**Rezoning Transportation Analysis**  
**Petition Number: Insert Zoning Petition #2021-062**  
*General Location Identifier: 14303106*

Date	Description
05-27-2021	First Review (KP)

SCHEMATIC SITE PLAN

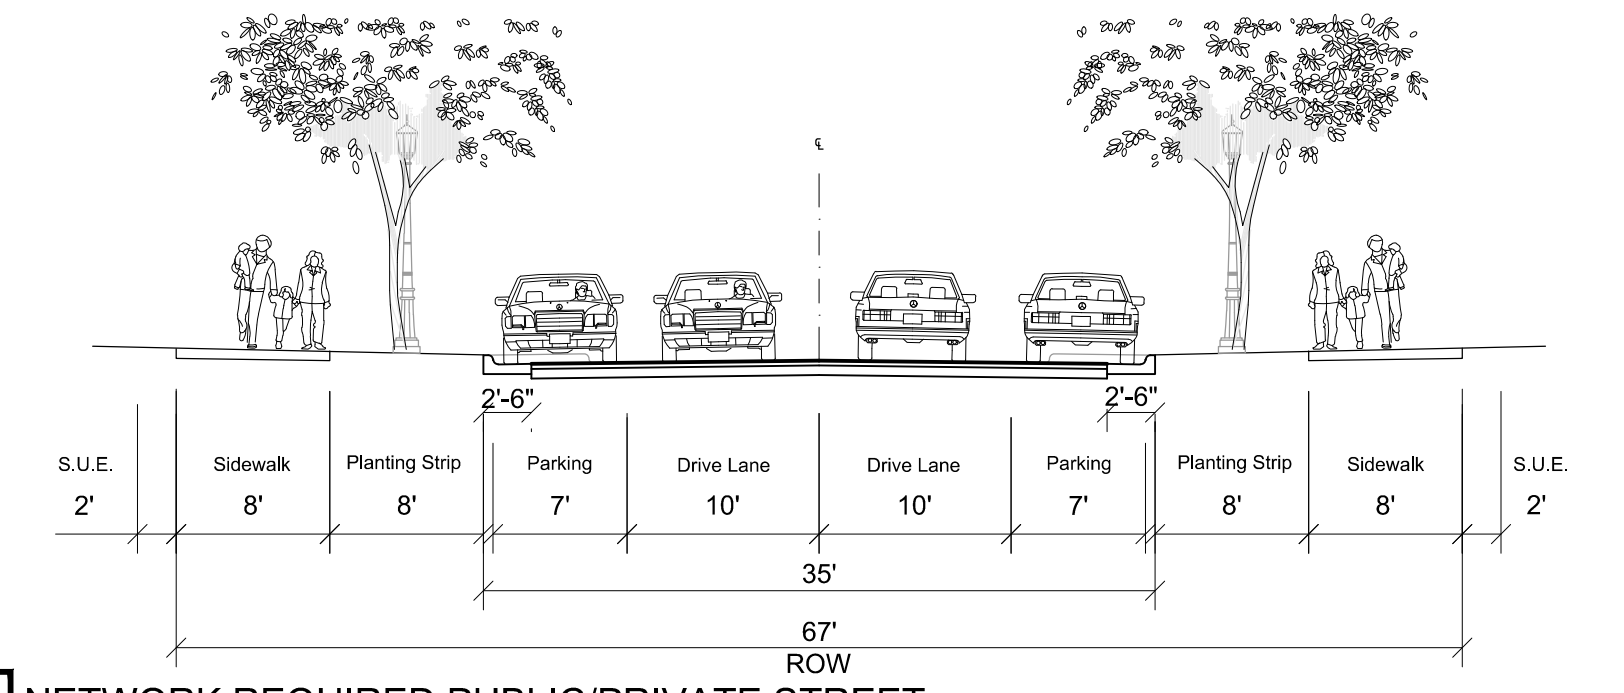
2. Revise site plan and conditional note(s) to reference the approved Accela Project number associated with Cross Stream Boulevard. Additionally, show the linework for the roadway and pedestrian infrastructure, including the right-of-way.

3. Revise site plan and conditional note(s) by clarifying the cross section associated with the private street. If the proposed private street is intended to be constructed in accordance with the Local Residential Wide Section, then the site plan needs to clearly label the private street as such.

- 4. Revise the site plan and conditional notes by removing the parking lot access driveway located in the curve of the private street.

- 5. Revise the site plan by aligning the centerlines of the driveways closest to the existing Cascade Pointe Boulevard street stub. This will mitigate the points of conflict along this proposed private street.

- 6. Revise the site plan and conditional notes by committing to connect to the northern site access into the existing stub adjacent to the VA Health Clinic, located on PID 14304106. The cross section and relative infrastructure should be clearly labeled and dimensioned.

- 8. Revise site plan and conditional note(s) by committing to include on-street parking, along the proposed private street, throughout the portion of the site's Townhome Development Area. This on-street parking will be designed and constructed in accordance with the CLDSM.
